Your Ref: 2021/93567

Our Ref: X018538

1st February 2023

Land off Westgate, Cleckheaton – Erection of 180 dwellings with associated works (Revised Description)

DRAINAGE APPRAISAL

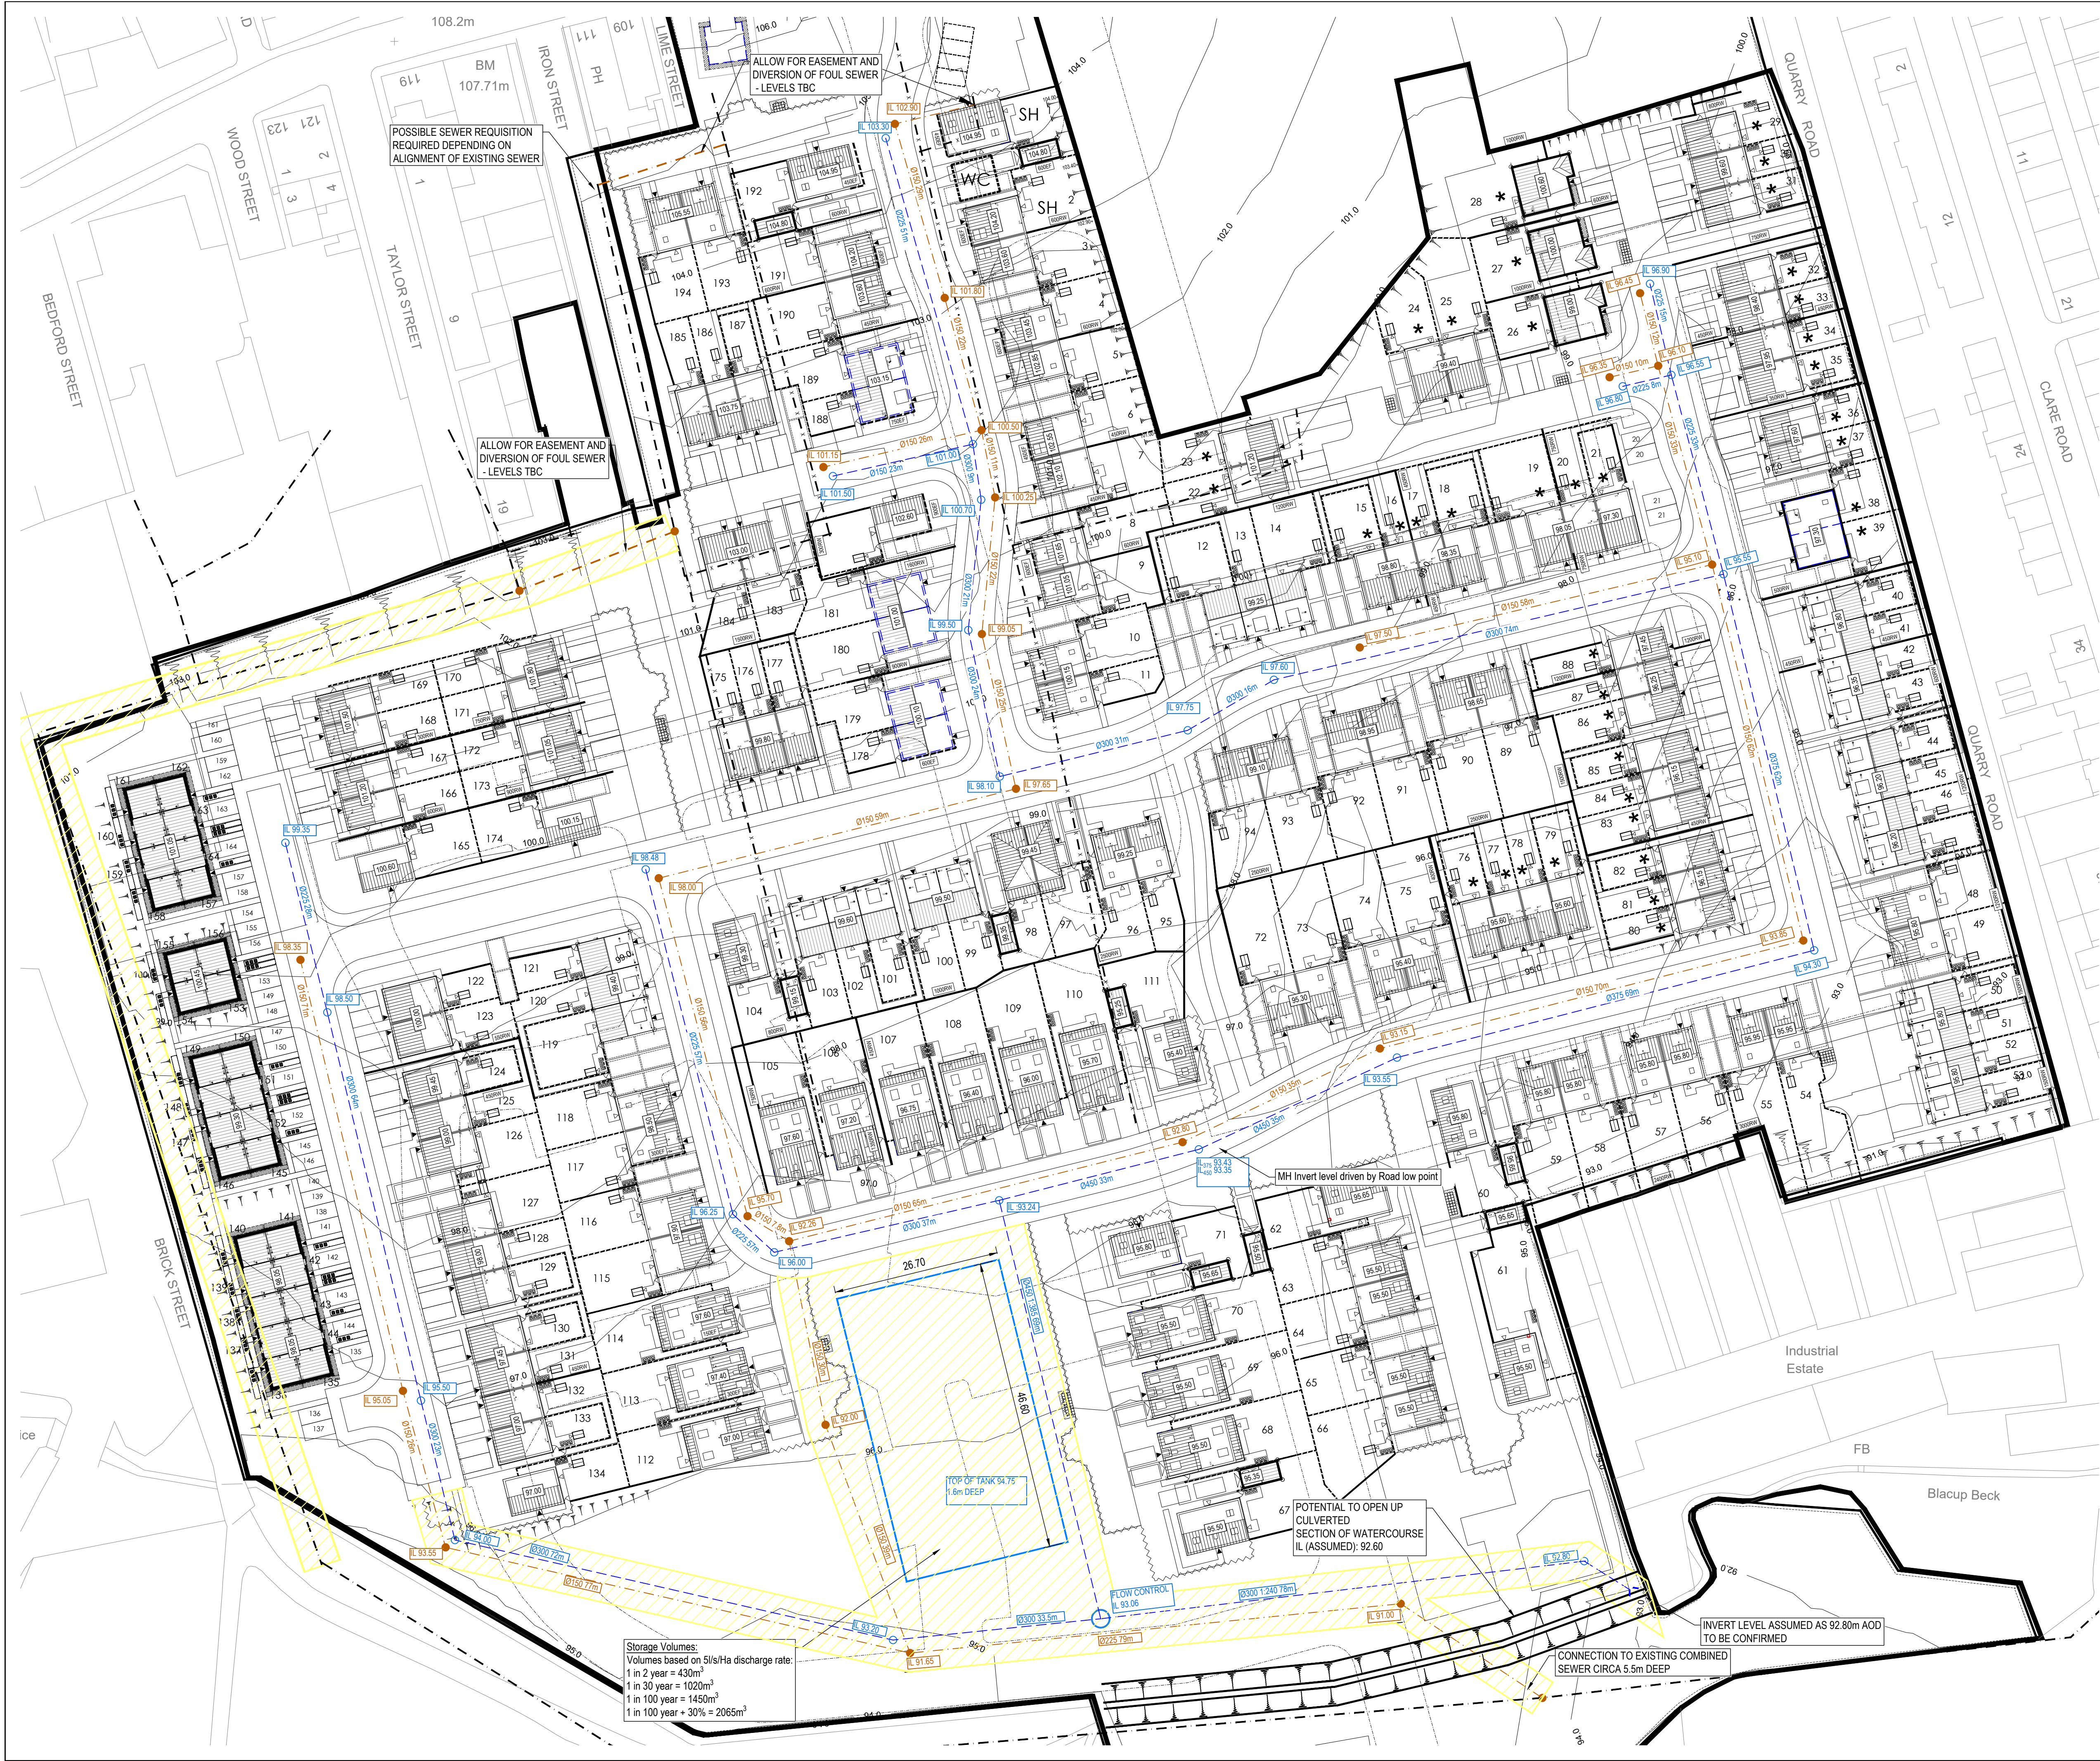
- a.) the submitted drawing appears new tree planting within 5 metres of the public sewer network.
- b.) the submitted landscaping drawing also indicates proposed 'heavy standard' trees to be within close proximity to the proposed attenuation tank which, if it is to be adopted by Yorkshire Water, may not be acceptable.

- c.) the submitted drawing should show the site-surveyed position of the public sewer crossing the site
- d.) the submitted drawing should show the required building stand-off from public sewer -- or an agreed alternative scheme.
- e.) the submitted landscaping drawing also indicates proposed 'heavy standard' trees to be within close proximity to the proposed attenuation tank which, if it is to be adopted by Yorkshire Water, may not be acceptable.

- a.) one 450 mm diameter public combined sewer;
- b.) one 225 mm diameter public combined sewer;
- c.) one 225 mm diameter public foul sewer;
- d.) one 150 mm diameter public combined sewer; and
- e.) numerous other small diameter foul and combined sewers, all of the above which crosses the site.

- a.) 5 (five) metres from the centre-line of the 450 mm diameter sewer;
- b.) 3 (three) metres from the centre- line of the 225 mm diameter public combined sewer;
- c.) 3 (three) metres from the centre- line of the 225 mm diameter public foul sewer; and
- d.) 3 (three) metres from the centre-line of the 150 mm diameter public combined sewer.

3.) It may not be acceptable to raise or lower ground levels over any of the above sewers and we will not accept any inspection chambers on any sewer to be built over. In addition, no trees are to be planted within at least 5 (five) metres of any public sewer.
